City of Portland, Maine - Building or Use Permit Application

Permit No: 02-0415	Issue Date: MAY 2 2002	CBL: 091 J008001
-----------------------	---------------------------	---------------------

Location of Construction: 27 Prince Ave	Owner Name: Moore Frederick W	Owner Address: 110 Sudbury Rd	Phone: 603-998-3024
Business Name:	Contractor Name: B.Z. Builders	Contractor Address: 47 Country Road Scarborough	Phone: 2078393851
Lessee/Buyer's Name	Phone:	Permit Type: Additions - Dwellings	Zone:

Proposed Project Description:
expand kitchen 4' x 6' & bath 8' x 7'

Floorplan
BZ/Moore Kitchen & Bath Room 1 Apr 15, 2002

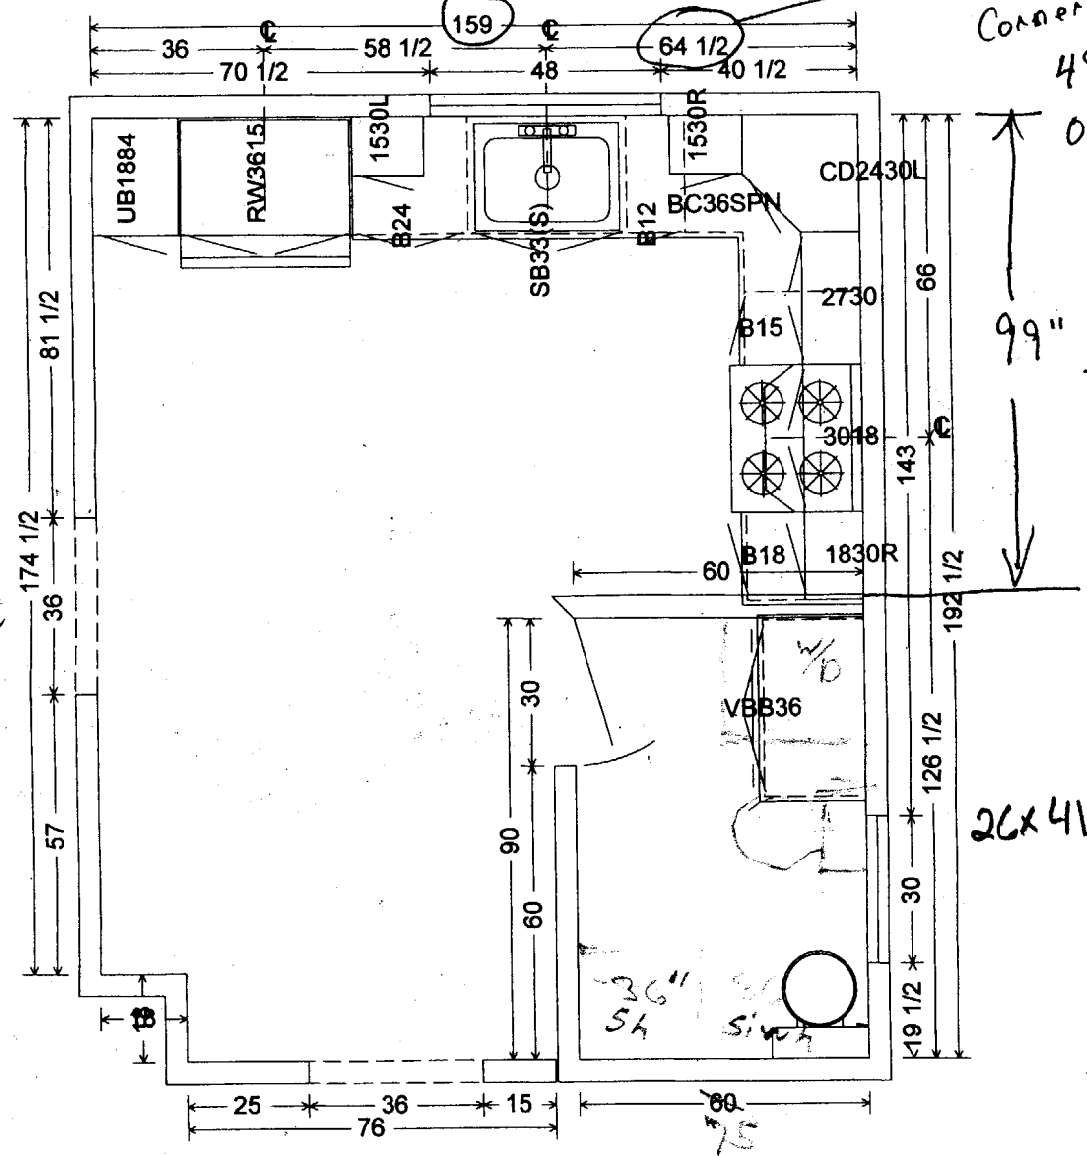
6/6/02 Framing inspection. No Room for 48" shower. Also,
New Deck built w/o permit contractor instructed to come
in w/ Application. New Deck is non-compliant. QR
